Application No: R/222/21/HH
Site Address: 42 Pigeonhouse Lane Rustington BN16 2BE
Description of works: Single storey rear extension and hip to gable loft conversion with 2 x dormers following the demolition of existing rear conservatory

Thank you for your internet representation made on 23rd October 2021 which has been recorded as an objection with the comments as follows:

A 02 :: Existing West Elevation
scale: 1:100

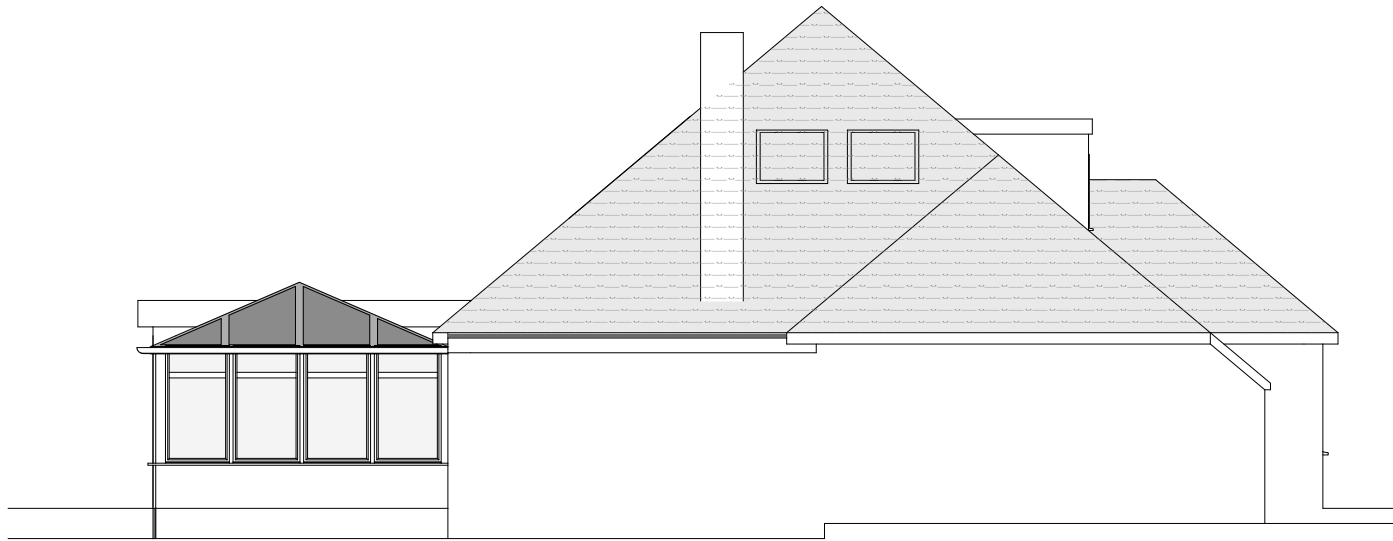
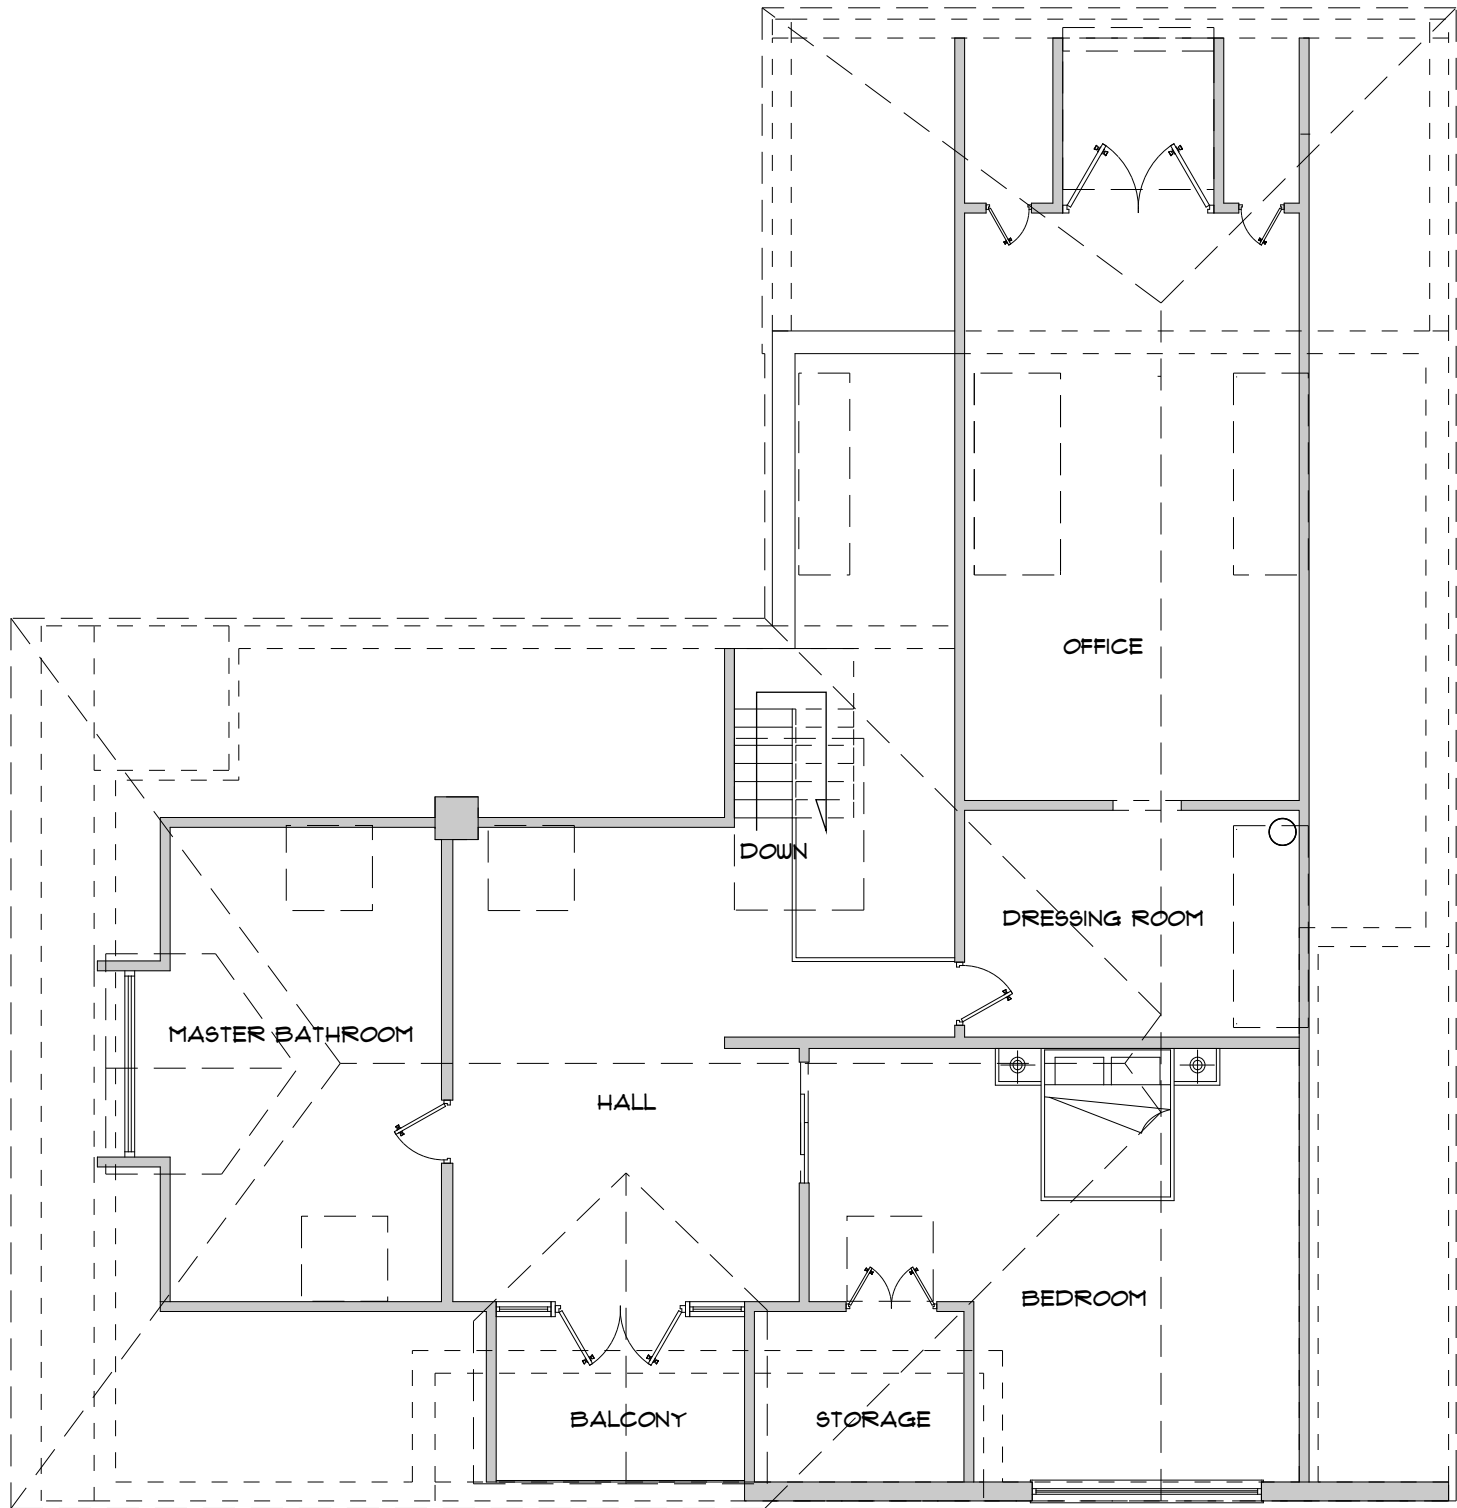
With ref to application number R/222/21/HH, we strongly object to the proposed works. Our property is 21 Frobisher Way and at the rear of the property in question. At present there is only one small window on the upper level overlooking our property (existing west elevation), and this is obscured by a tree, which is not TPO'd. The number of windows now proposed at the rear of the property - overlooking our property - would increase around six times - including a new additional balcony. This is totally excessive and unacceptable. If it were the other way around and we submitted such an application to add another floor to our property - we are certain that a similar strong objection would be received from 42 Pigeonhouse Lane. We apologize for missing the cut off date for comments but we have been away and only just seen your notice. Thank you.
